CITY OF ALBUQUERQUE

**Re: Plaza Ciudadana Conceptual Grading and Drainage Plan, Engineer's Stamp
Dated 11-08-2012 (H14/D002)**

Based upon the information provided in your submittal received 11-13-12, the above referenced Grading and Drainage Plan is approved for Building Permits with the following comments:

**C-201**

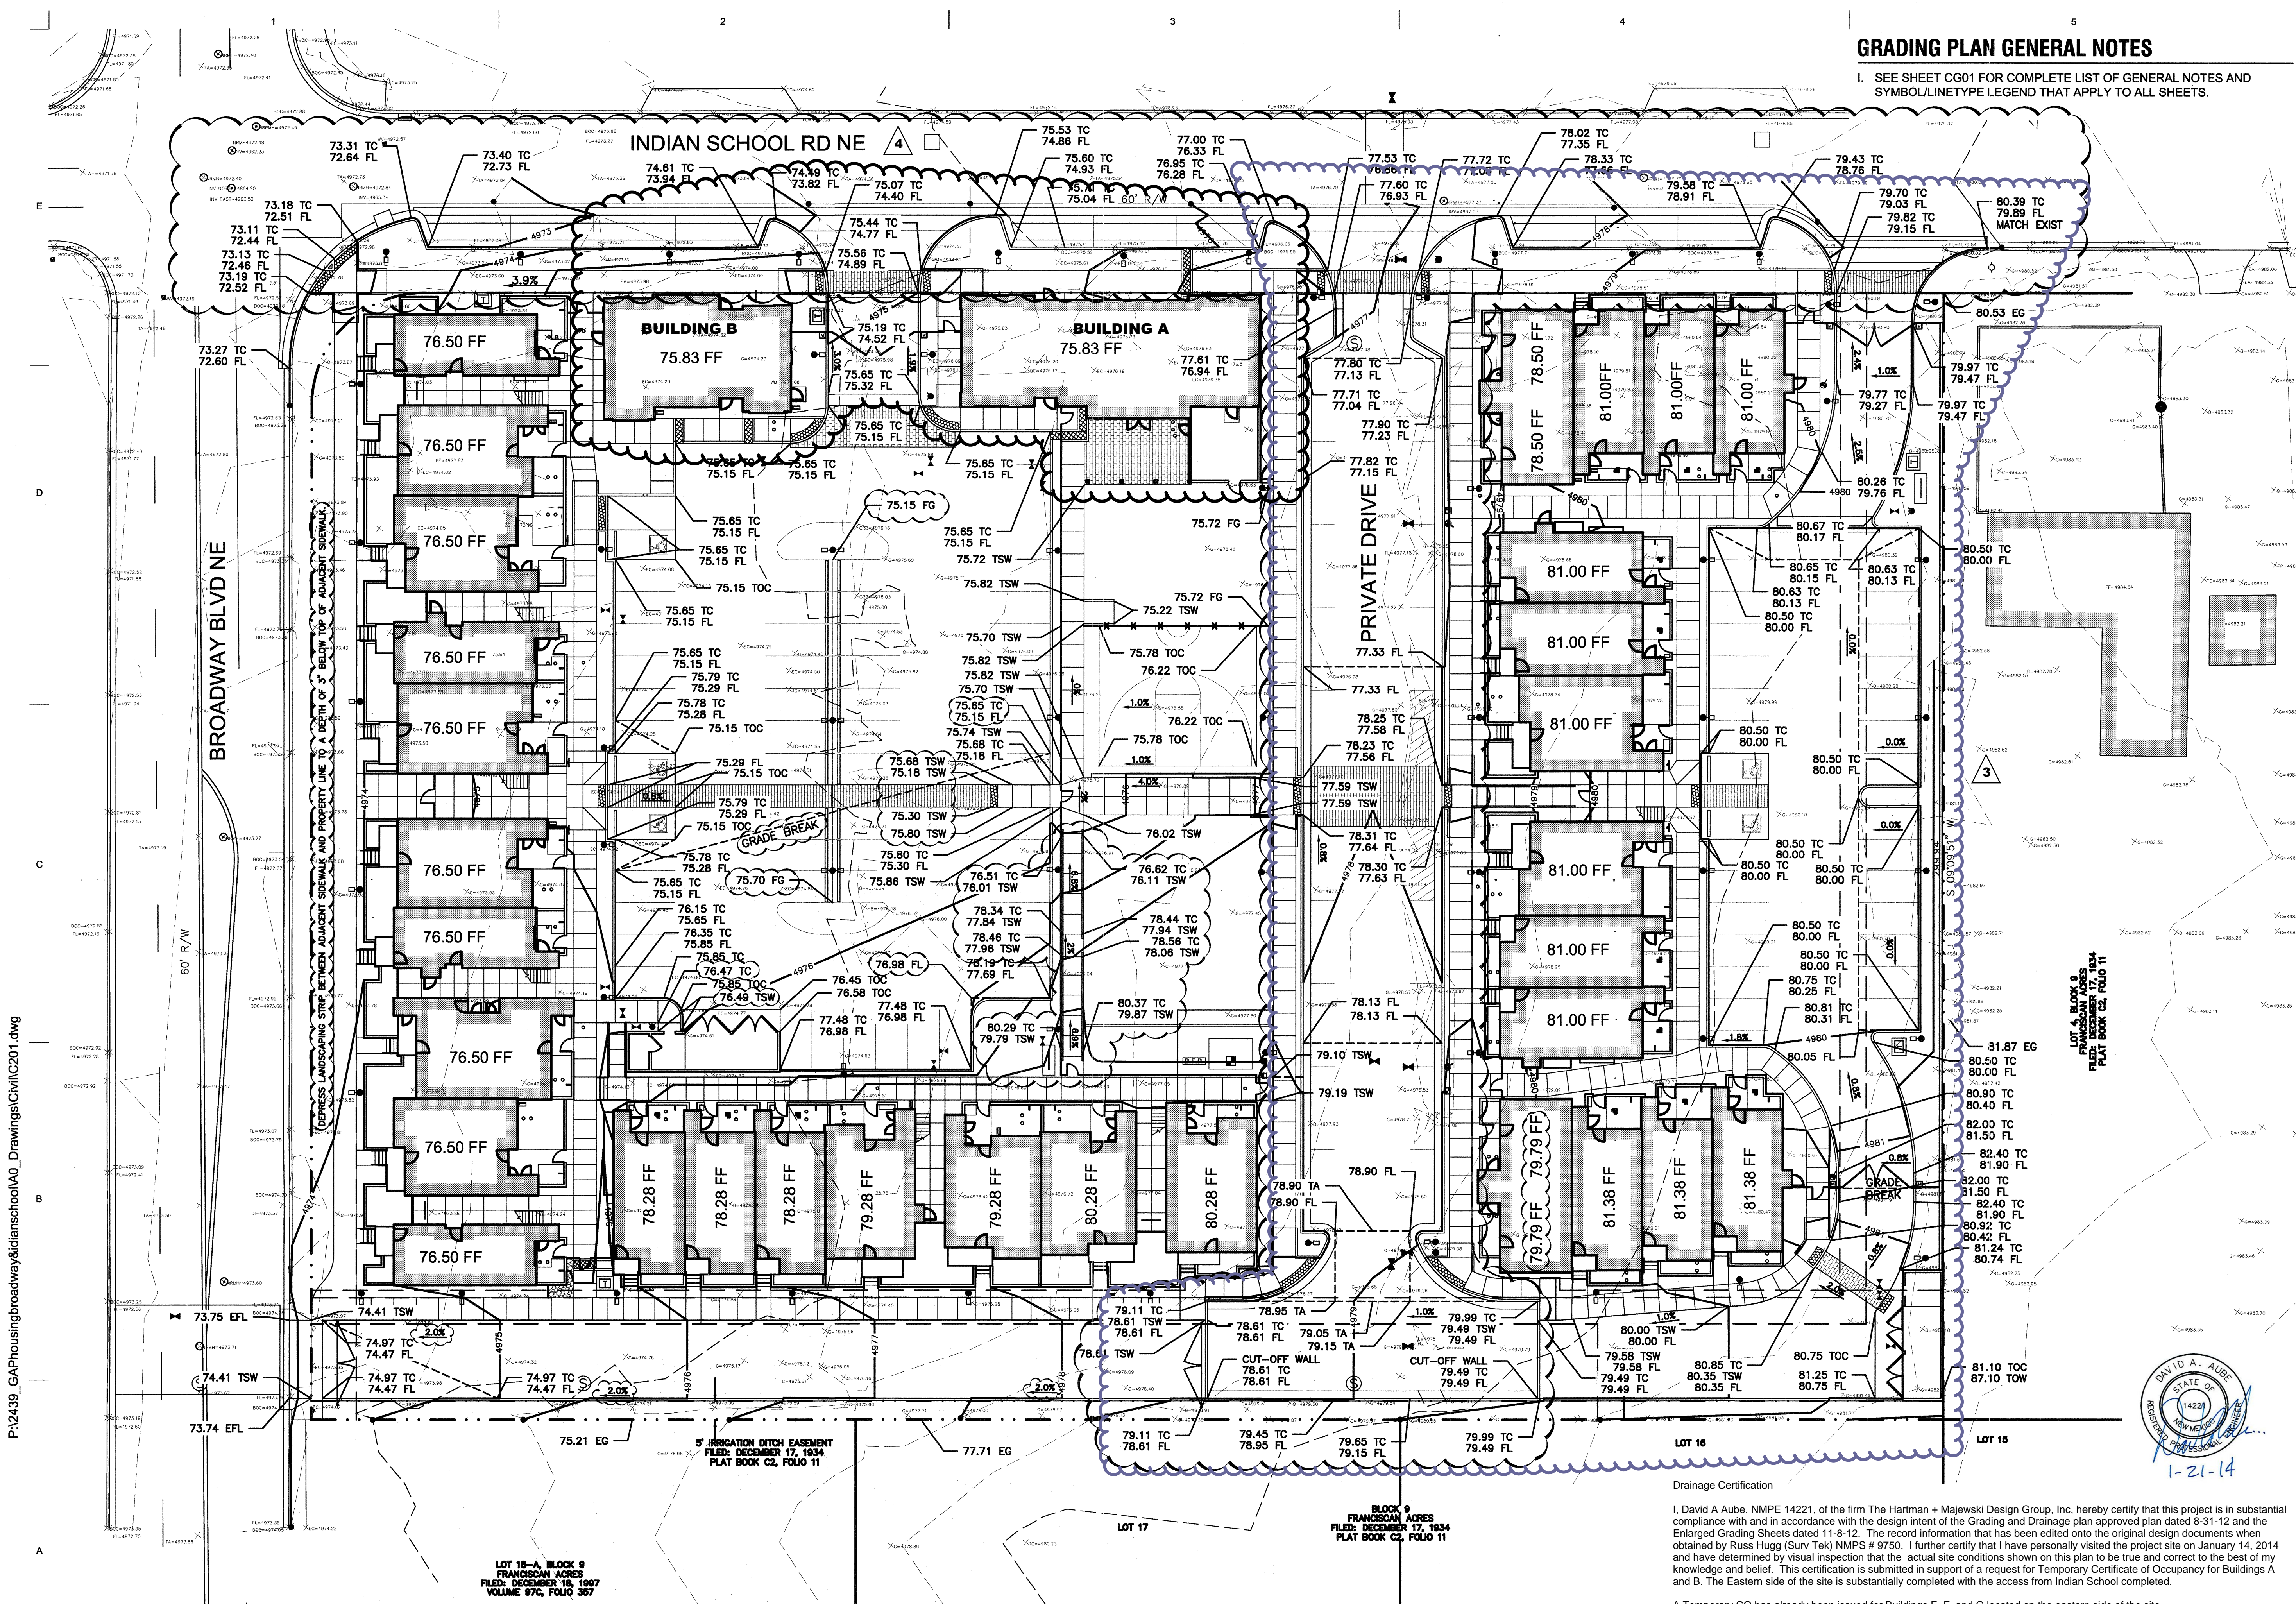
- Correct the elevation at the entrance.
- Sheets C205 and C206, flat grades to be changed to provide positive drainage.
- Sheets C210 and C211, add additional elevations by the patios to assure positive drainage.
